From: Elaine Walby on behalf of Planning.Responses
Sent: 07 May 2026 16:00
To: Planning Scanning
Subject: FW: Public comment on application A/44/26/PL
Attachments: Neutral review of Application 7.pdf

Technical and Procedural Review of Application A/44/26/PL

1. Executive Summary

KEY TO HEALTH AND SAFETY SYMBOLS

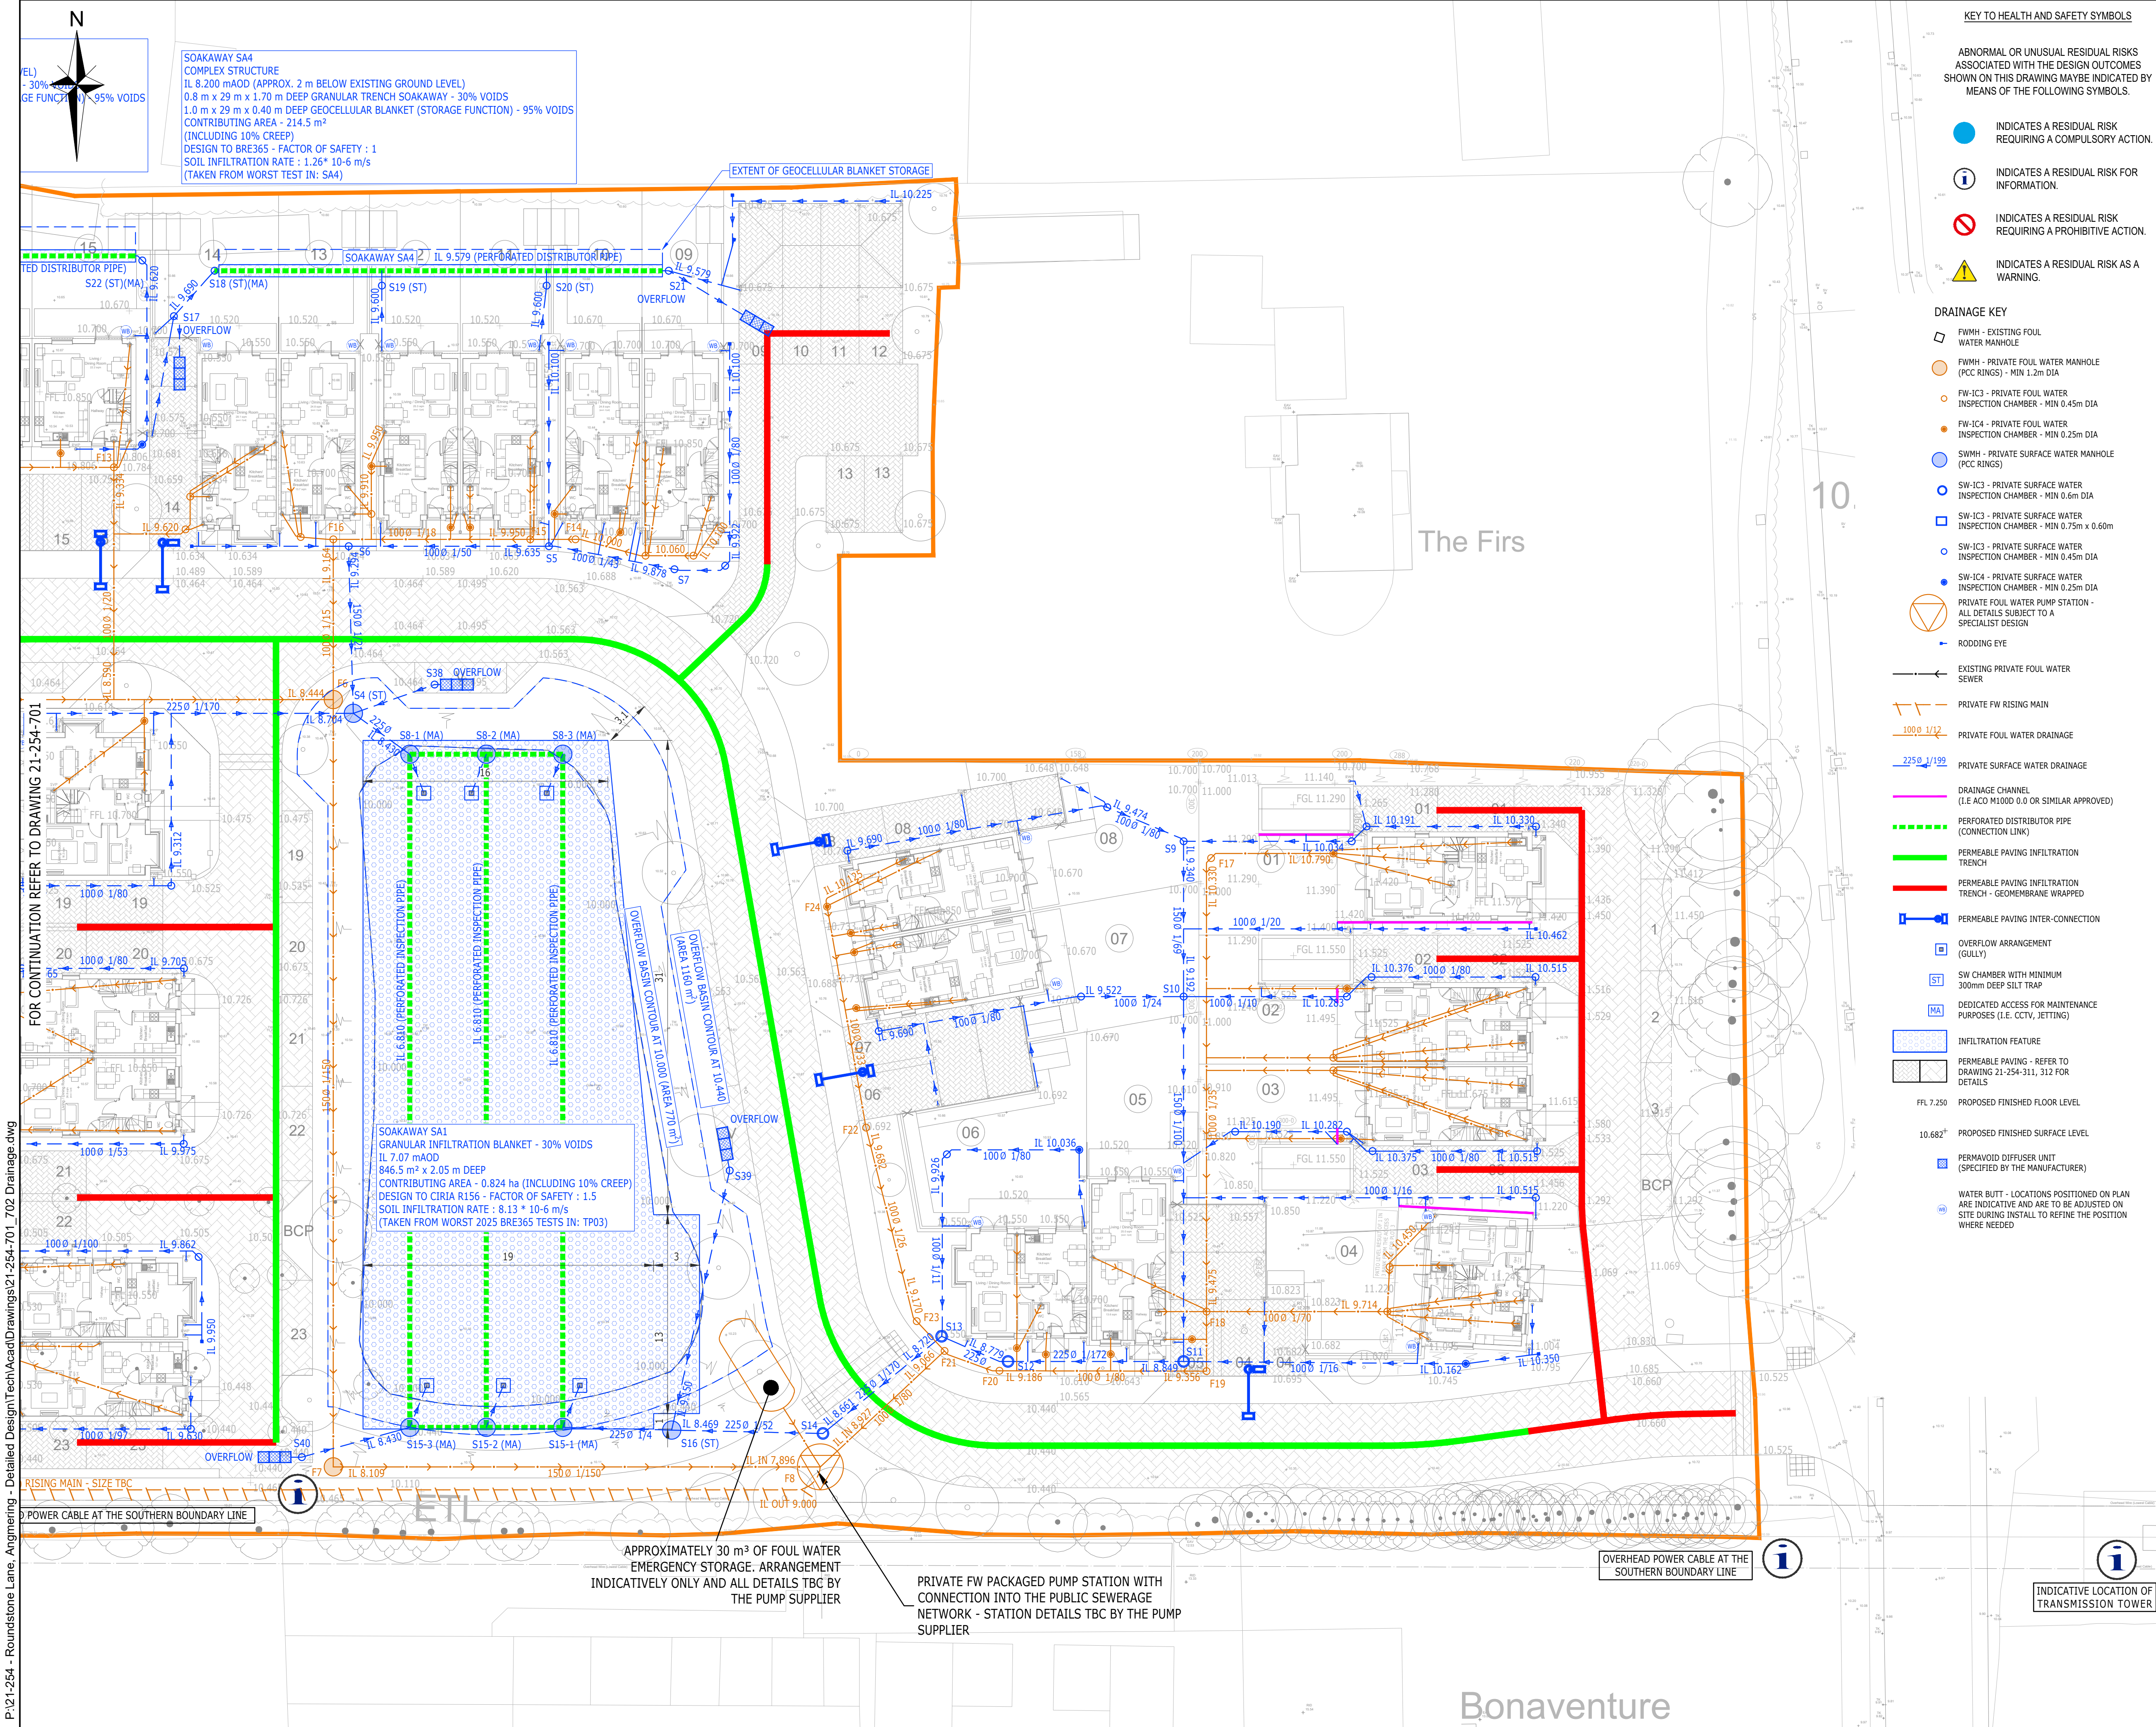
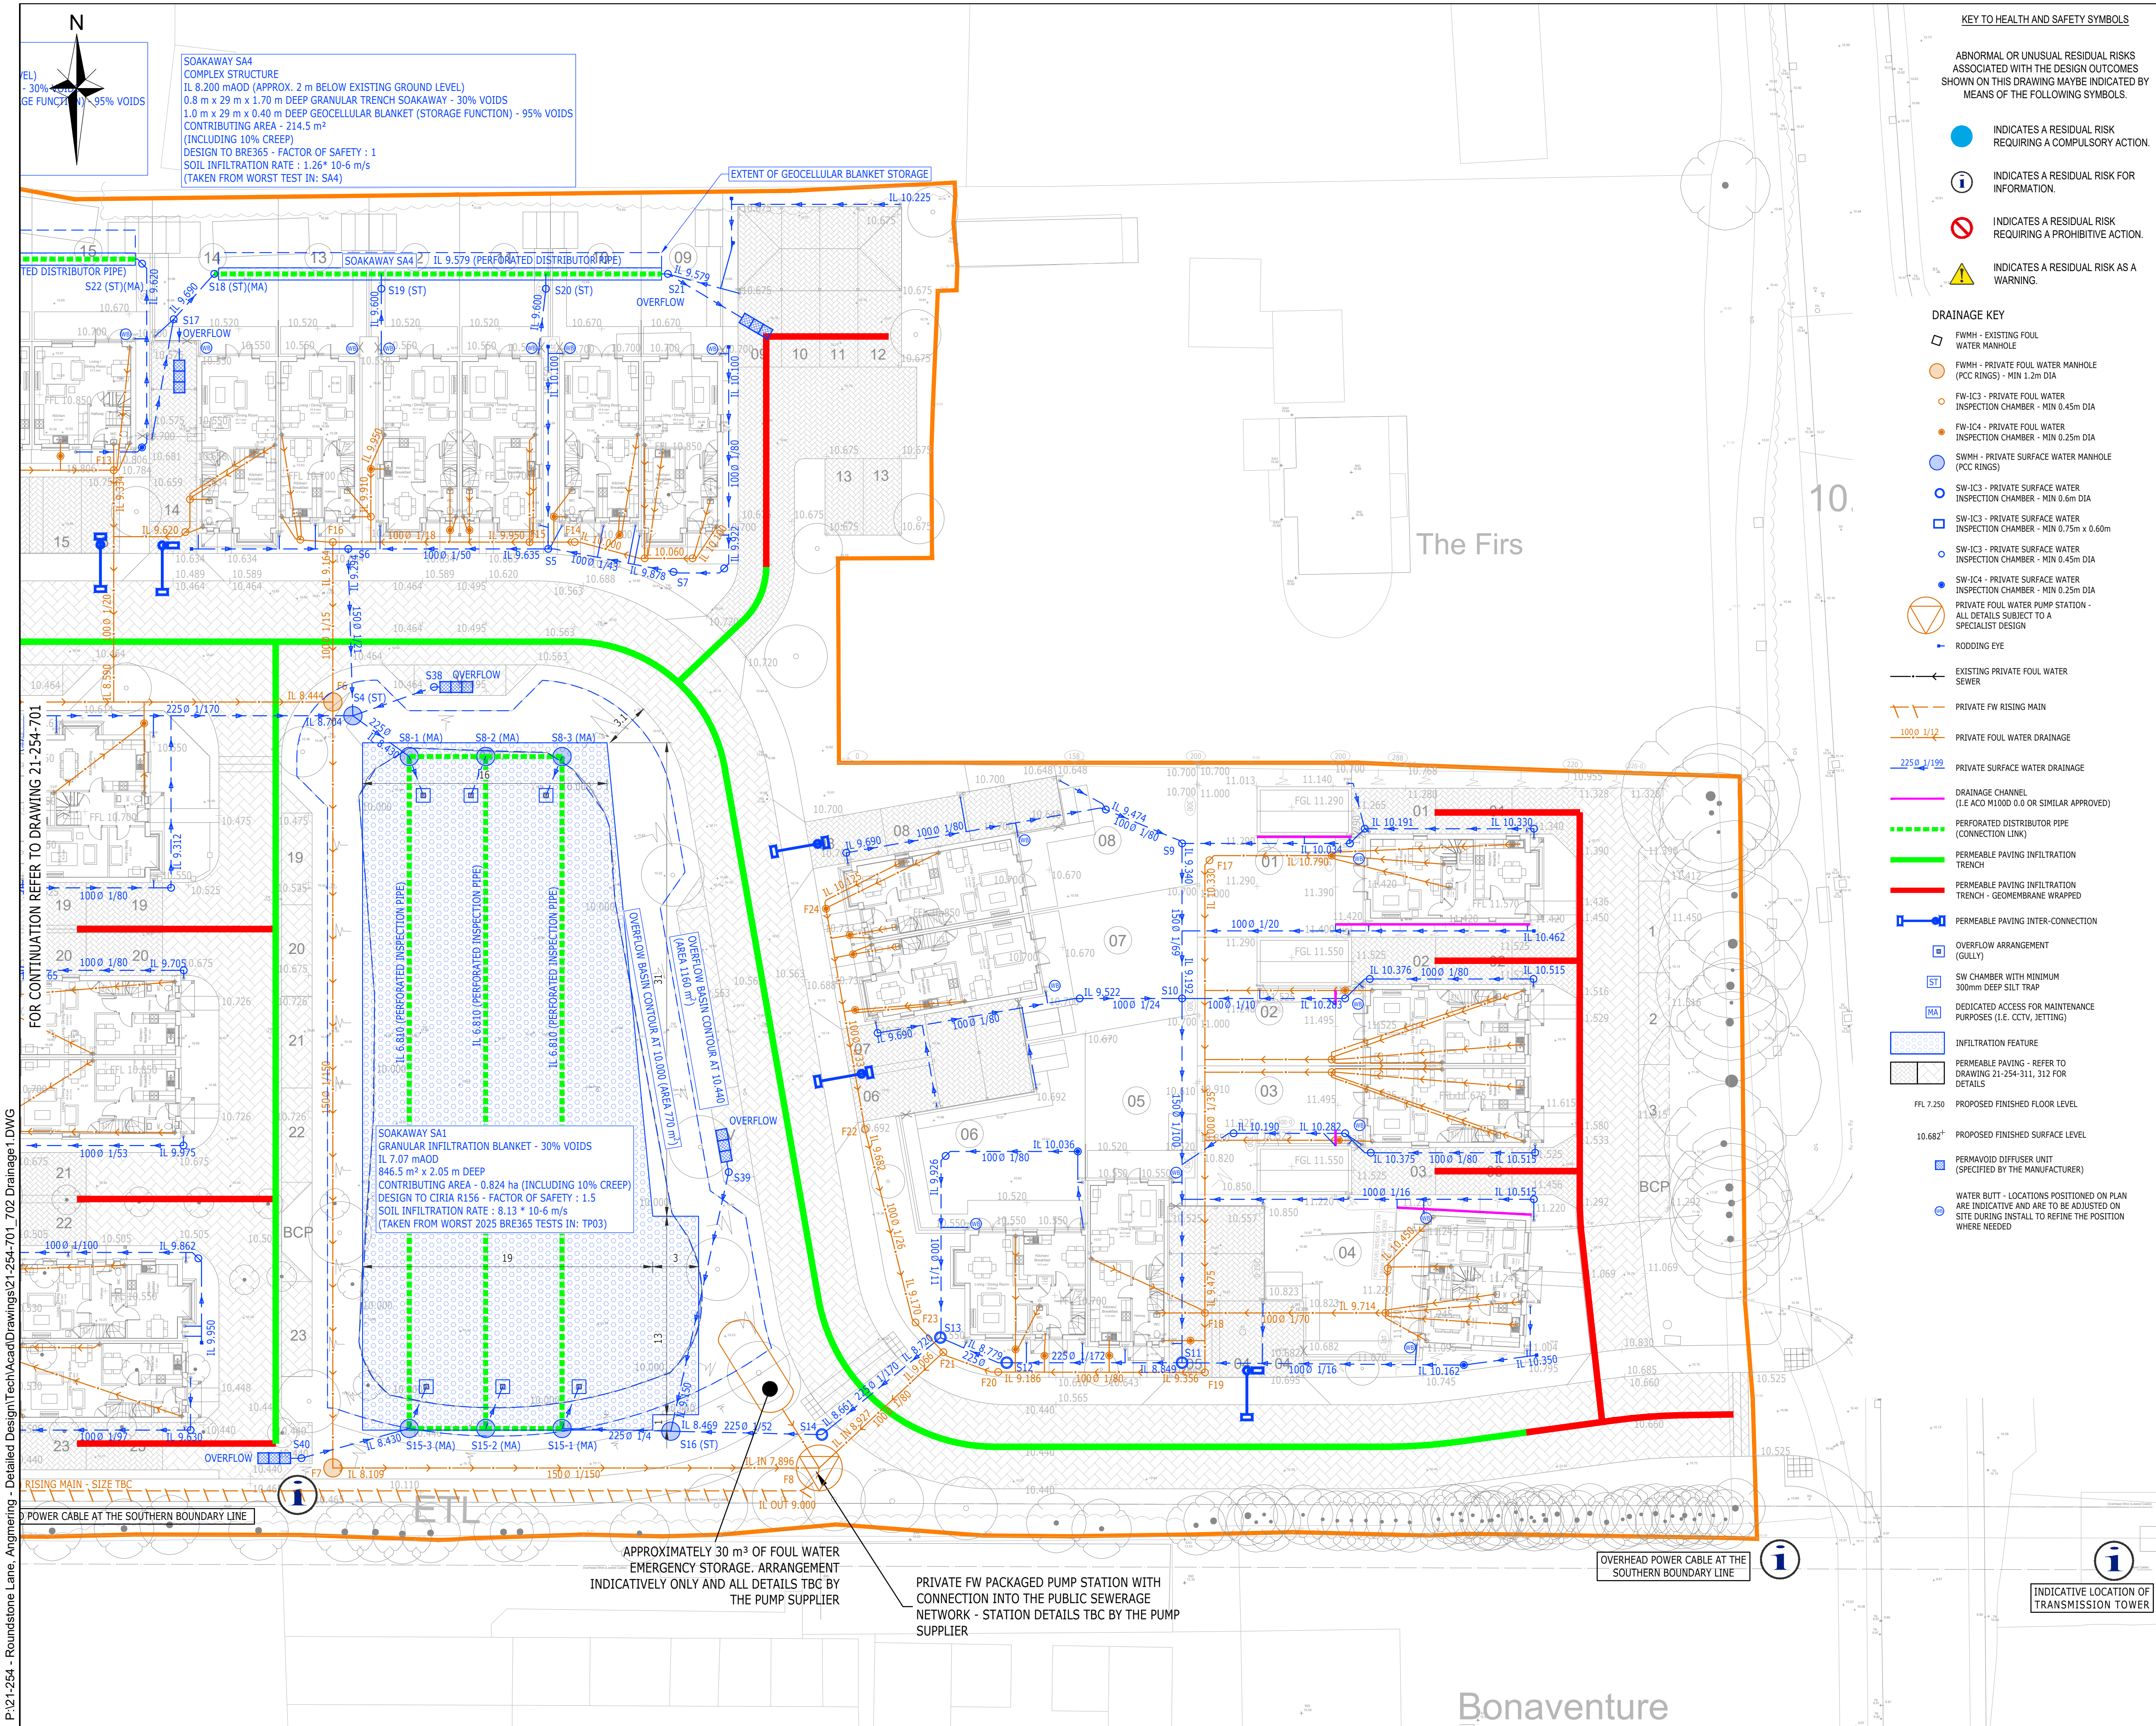
Features shown as present on the drainage drawings, including a rodding eye and inspection chamber with stated invert levels beside Plot 4, were not constructed on site. In addition, not all drainage construction drawings previously before the LPA appear to have been submitted with the present application.

Whilst it is noted in 2.7 that the surface water drainage management plan has been omitted from this submission, one assumes that any such plan would include the use of rodding eyes and inspection chambers such as these. This then raises the question as to how the plan can be coherent and executable if essential elements of the drainage system have not been constructed. The omission of these two particular features had already been brought to ADC's attention on 13 February 2026, almost a month before the date of this latest application.
